The Moat Farm, The Street, Hinderclay, IP22 1HX

This document is in response to planning enforcement documentation EN/21/00838, received 2022/12/15 regarding the renovation and refurbishment of The Moat Farm. The following information is to outline works done on the above listed property and answer queries/concerns raised by the planning authority. Photo locations can be found in accompanying documents A-1003 and A-1004

Response to request for information received on 2022/12/15

Drawing Number  
Moat Farm-xx-dr-a-ele-1001

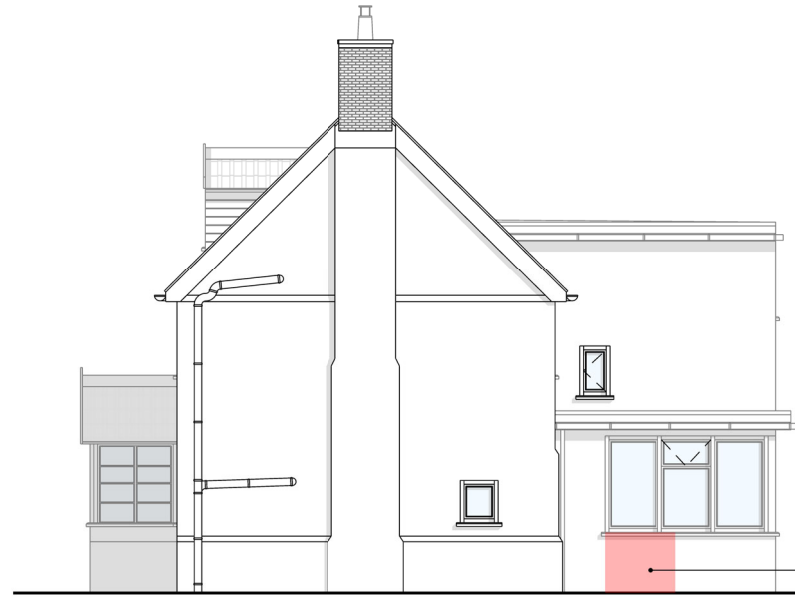
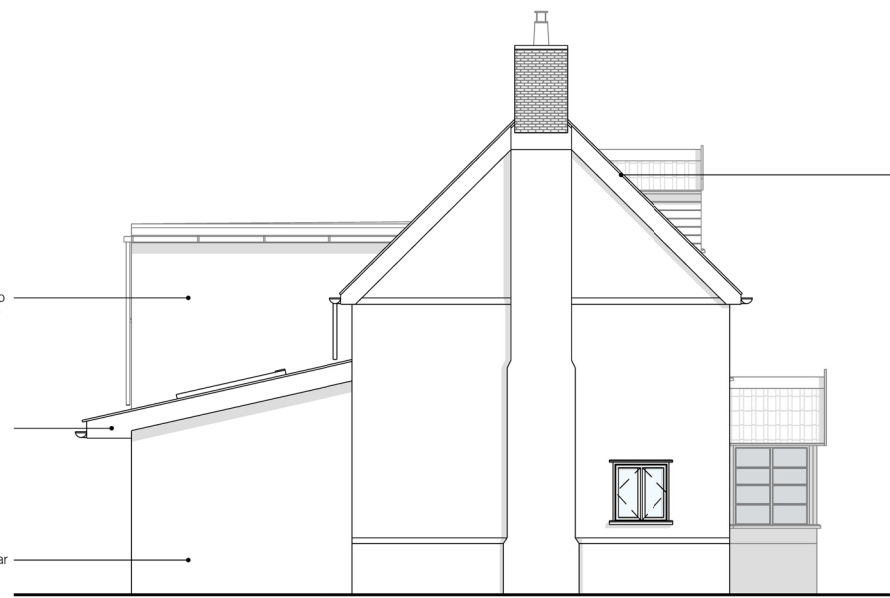
MD photo	LBC needed	support	comment	Summary Response
REAR EXTENSIONS					
Re-render s/s and 2/s extns	31	Prob N		Assume material is same as previous	Repaired due to water damage, materials match existing

Extension's rendering showed signs of water ingress and was beginning to crack and separate from the wall. Repairs were made where possible and re-rendered where necessary using materials to match the existing condition

Proposed - Plan - 01
1:100

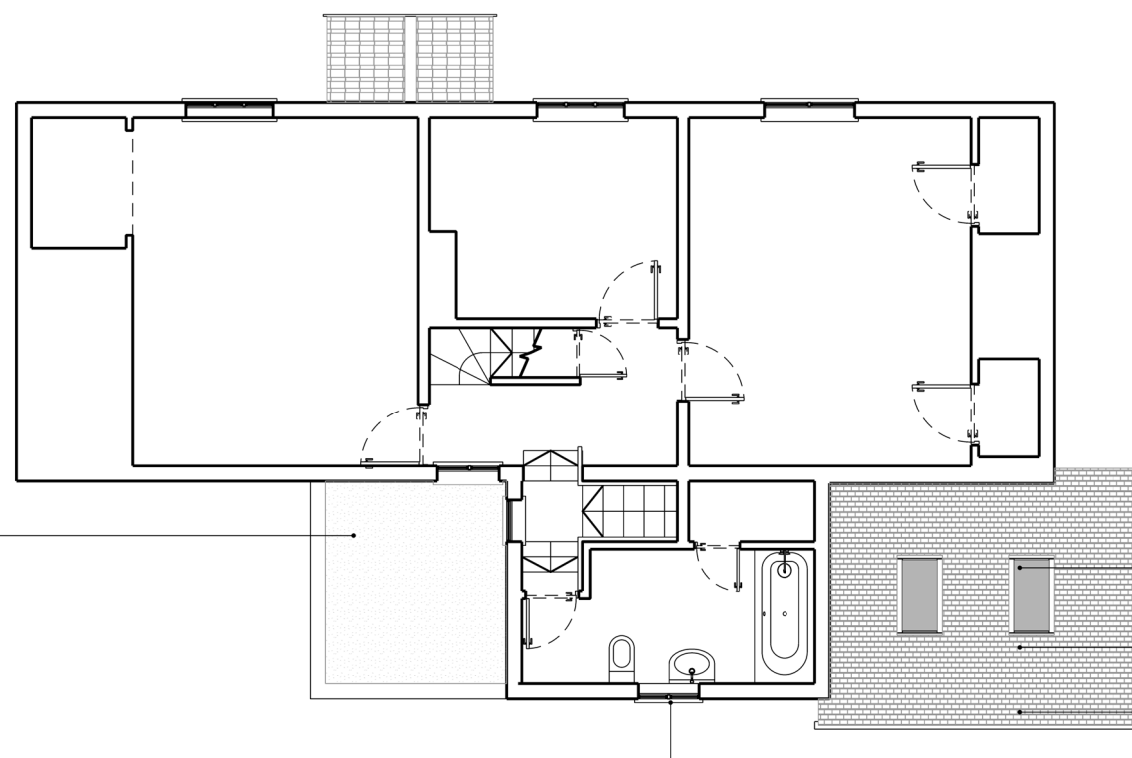
MD photo	LBC needed	support	comment	Summary Response
REAR EXTENSIONS					
insertion of 2 rooflights		Y	Y	Over the 'porch' ?	Installed into modern extensions during roof repairs

During repairs of the SE C20 sloped extension we chose to install 2 rooflights to enhance the interior space and improve natural light penetration to the kitchen situated within the historic part of the property.

Proposed - Plan - 00
1:100

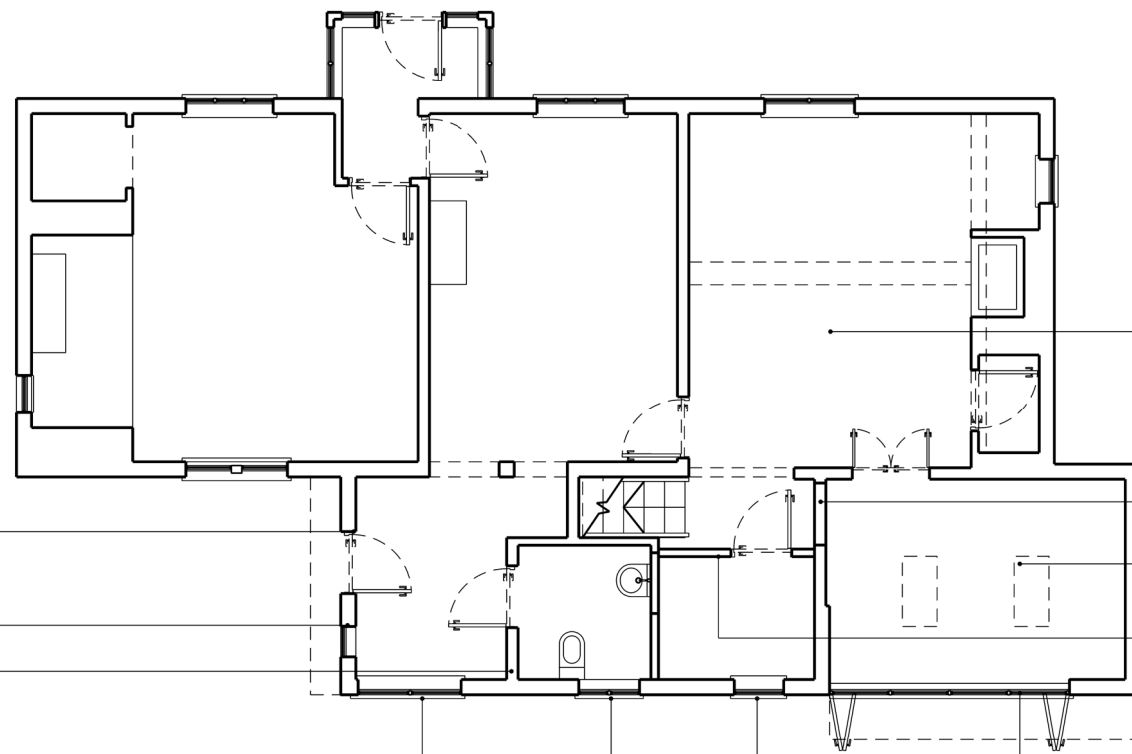
MD photo	LBC needed	support	comment	Summary Response
REAR EXTENSIONS					
Replace corner window extn with door and window	31, 36, 46	Y	Y		Evidence of existing doorway during repairs, decision made to reinstate

During repairs of the C20 SW extension walls and windows evidence was uncovered in the masonry that there had previously been external access. It was decided to restore this route as it created a more direct link to the external parking area and a more natural access point to the property.

MD photo	LBC needed	support	comment	Summary Response
OTHER					
New door opening from porch to kitchen ?	36, 46, 50, 108	Y	Probably N	potential loss of historic frame; refuse unless clear evidence it was a previous opening; reinstatement might not be desirable.	An existing window, decision to convert to doorway to after uncovering evidence of previous doorway/failing repair

Existing window opening. During reparations to wall multiple masonry infill patches were uncovered, difficult to determine if it was a previous doorway or poorly repaired. Decision was made to remove the failing repair and convert to a doorway to provide a direct link from the kitchen to the extension and improve natural light penetration.

Client	Tim Baldwin	
Project Name	The Moat Farm	
Stage	Planning	
Drawing Title	Proposed Window Detail WS-0107	
Drawing Number	Moat Farm-xx-dr-a-ad-1009	
Scale	Sheet Size	Creation Date
1: Mixed	A3	19/05/2023
Revision	Suitability	
01	For Information

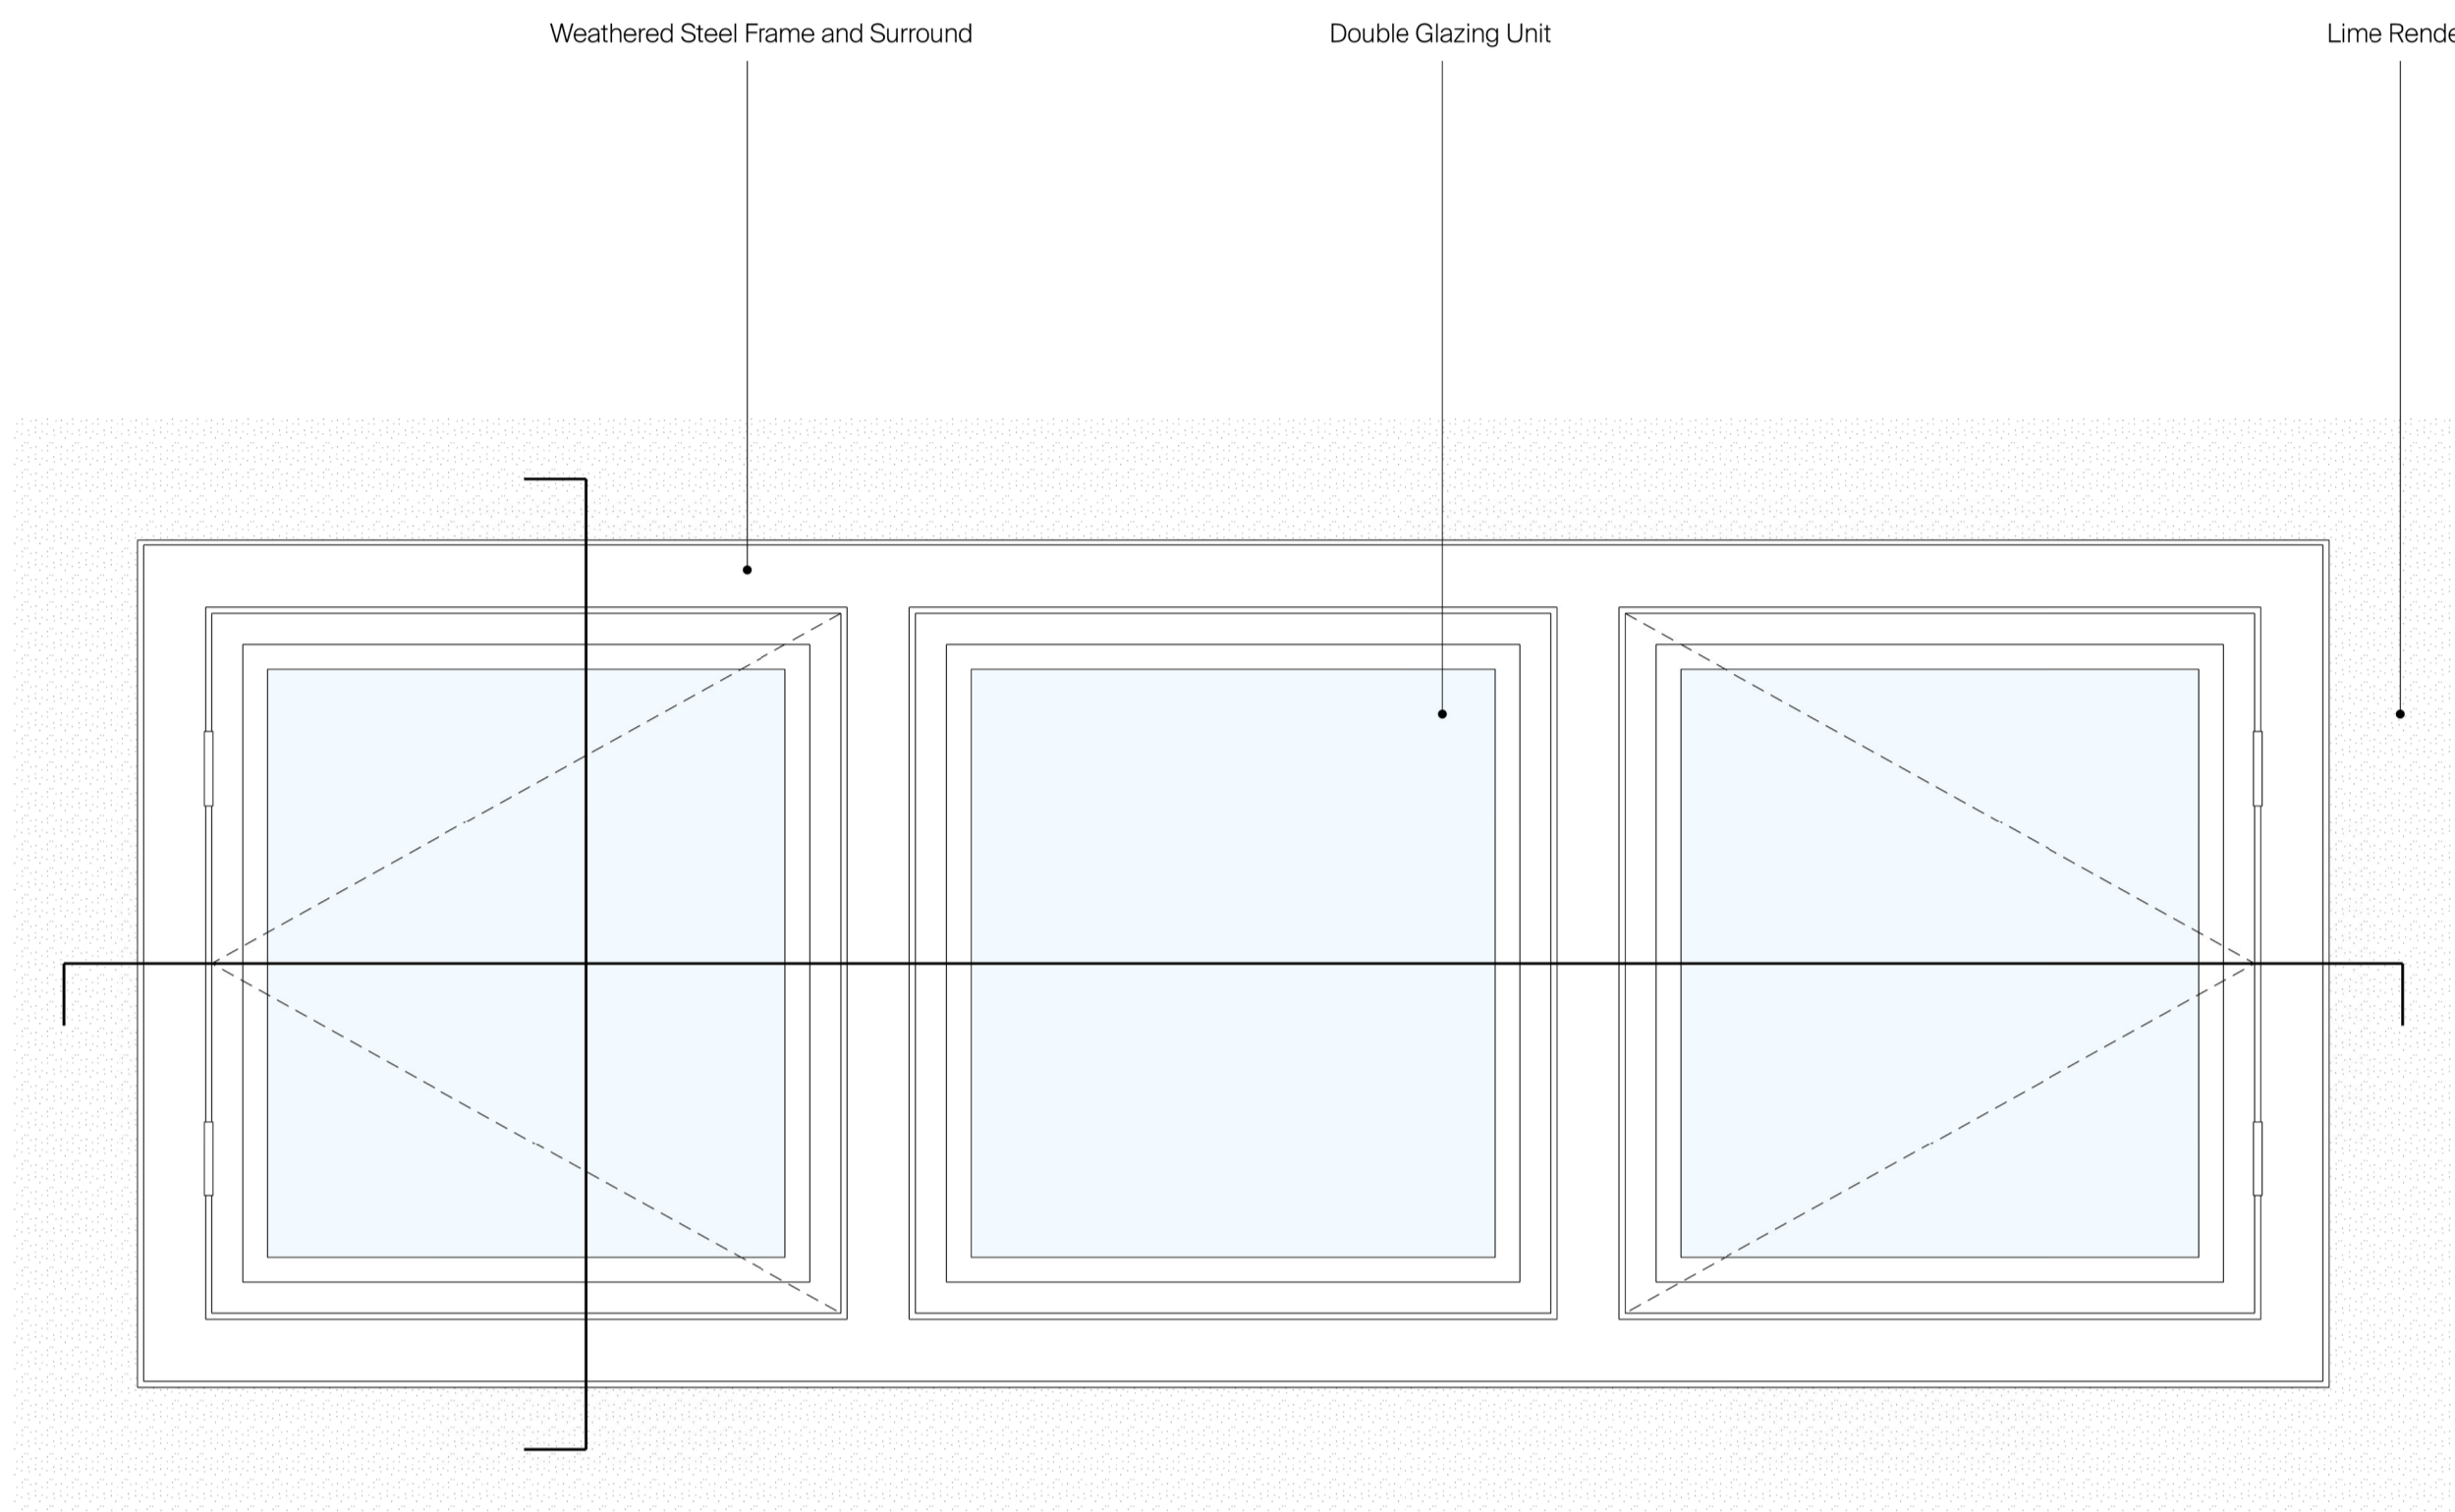
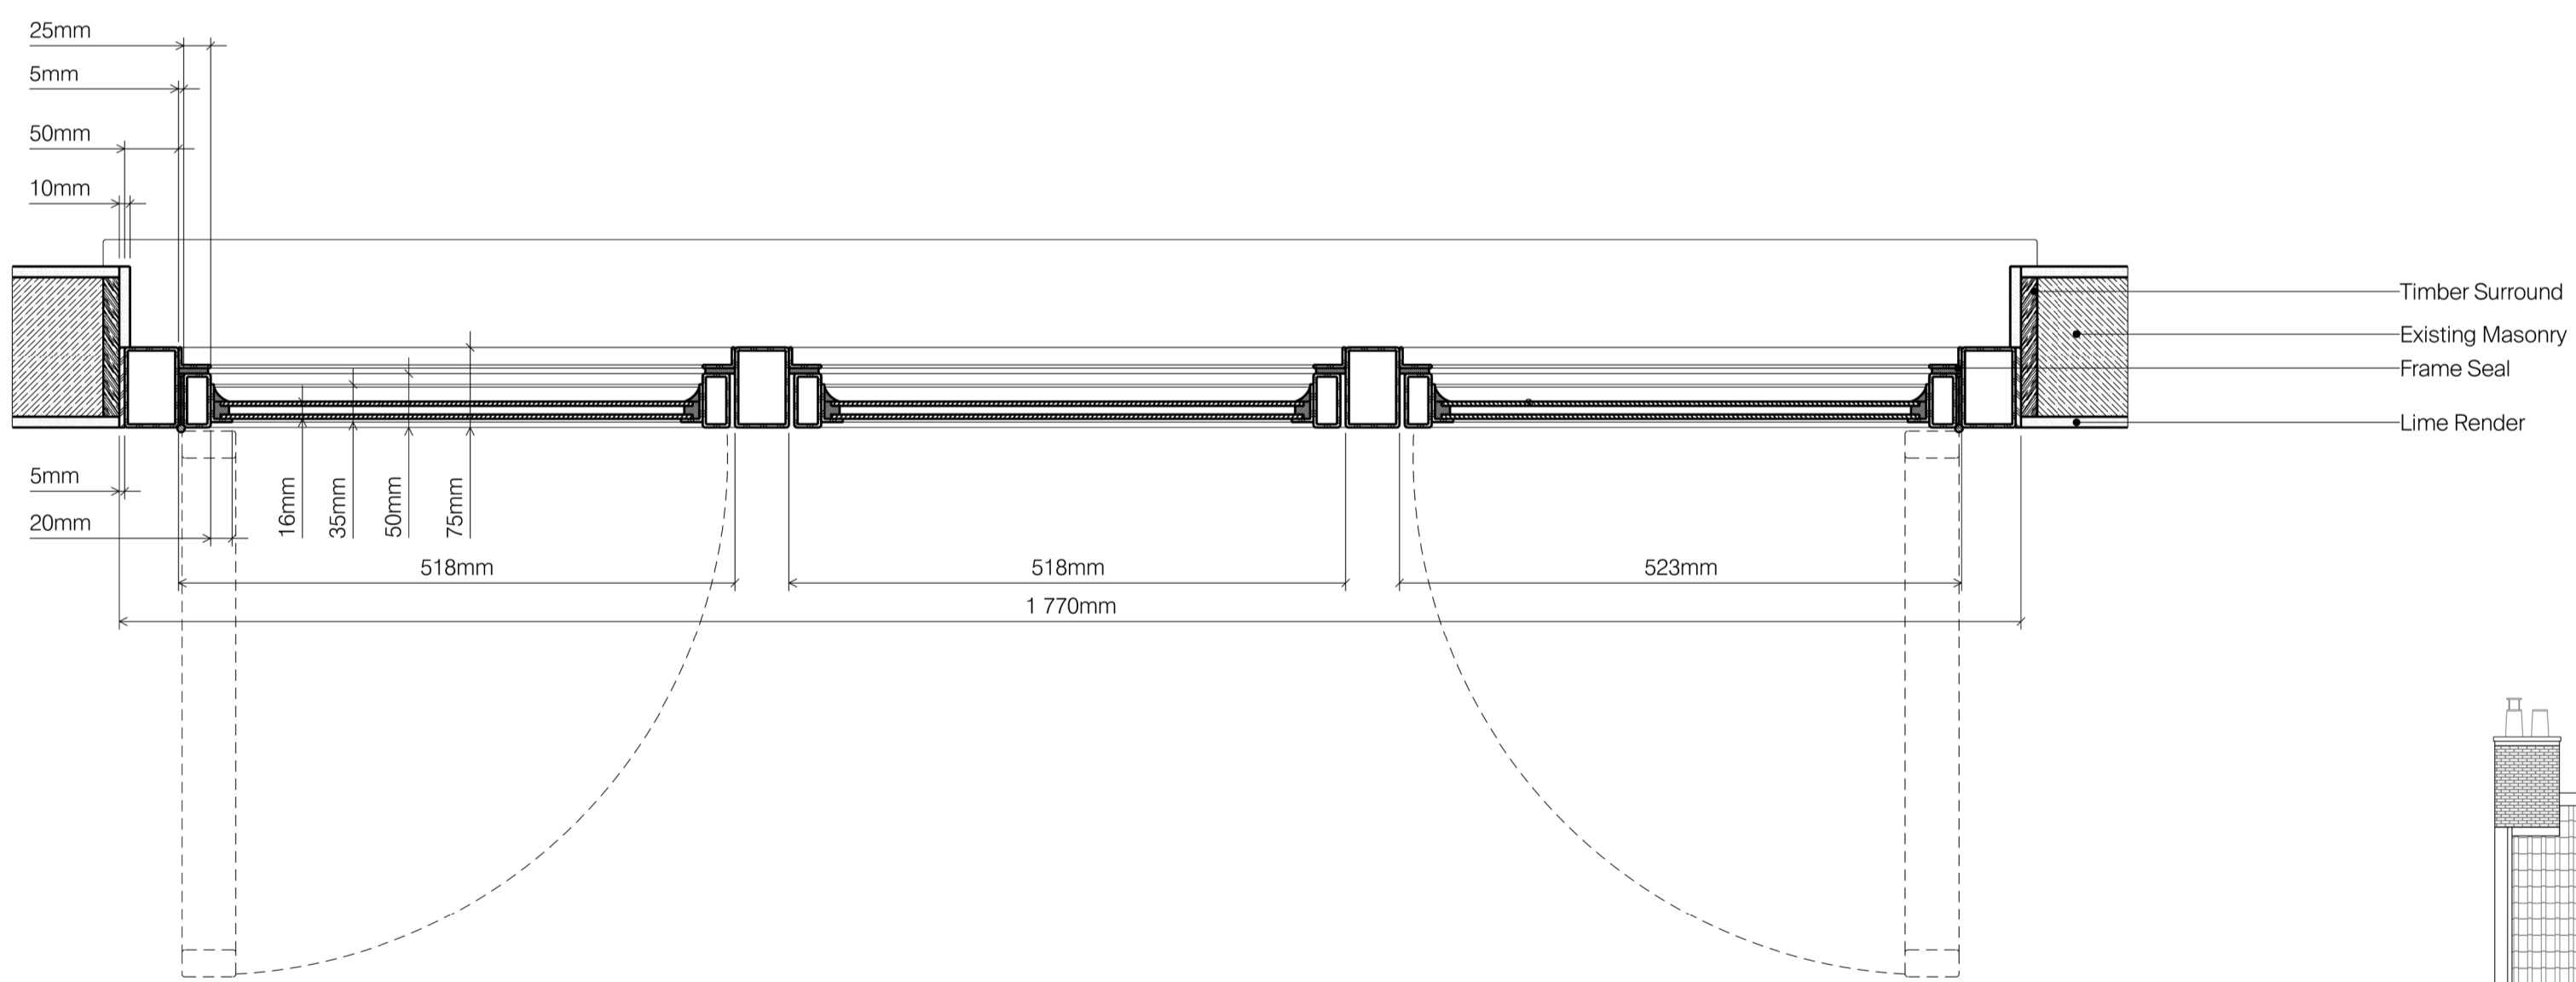
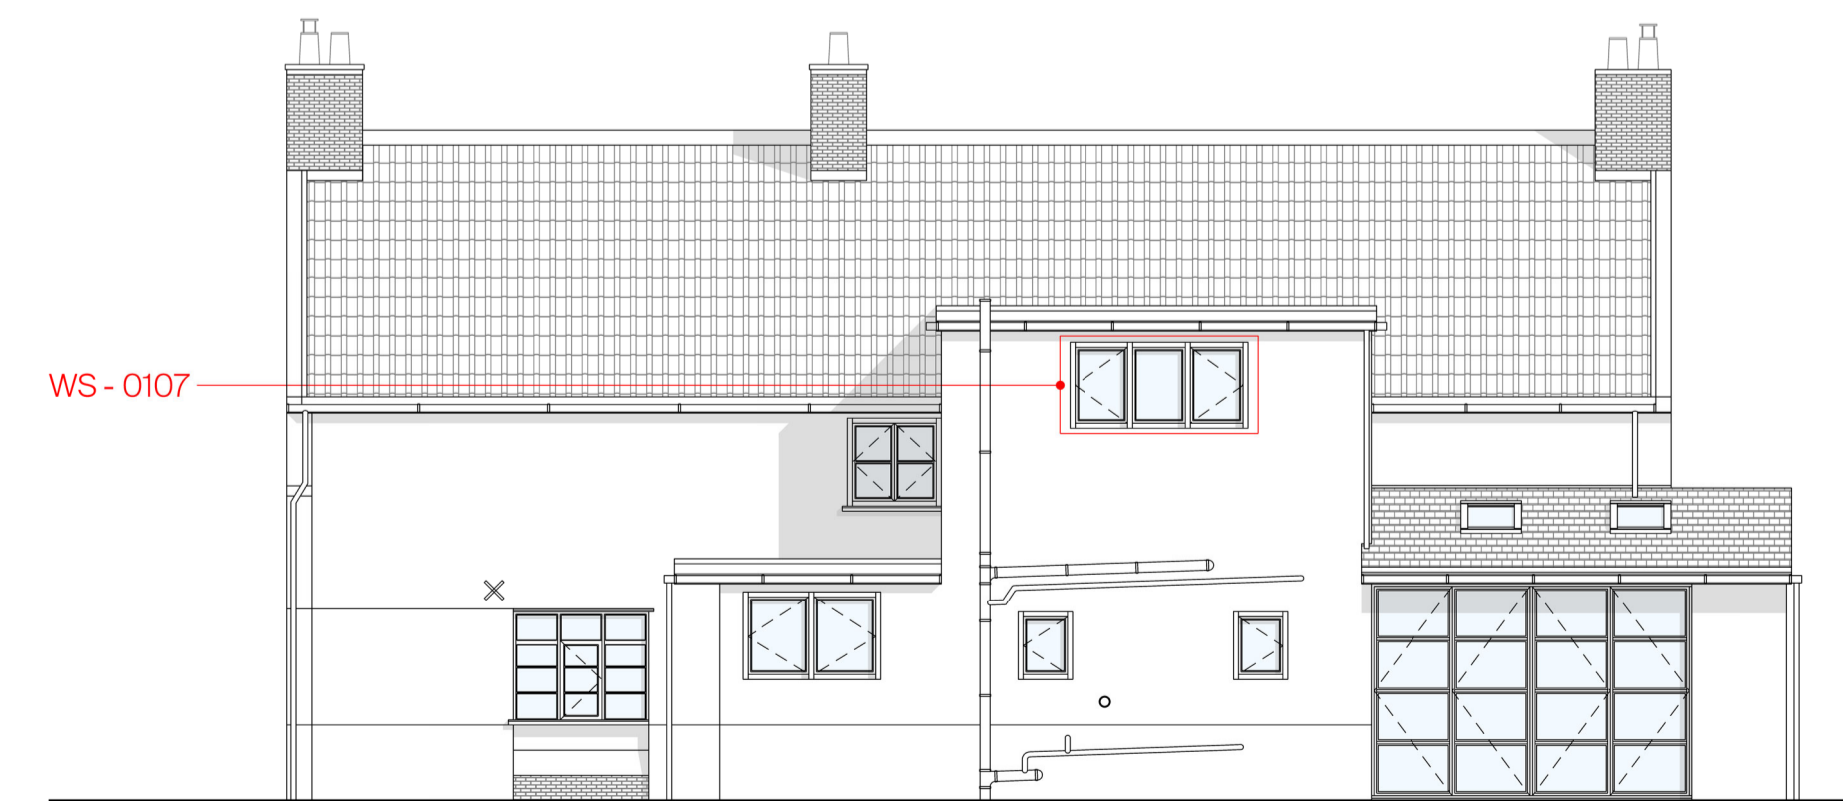
MD photo	LBC needed	support	comment	Summary Response
OTHER					
New rusty windows to extns	57 etc	Y	Y	replacing Crittall, and don't look bad	Existing timber window surrounds damaged, decision made to replace with similar to historic crittall windows

The existing timber surround Crittall windows in the SW and SE extensions had sustained water damage and as a result had extensive rot. The choice was made to replace with similar steel Crittall style windows.
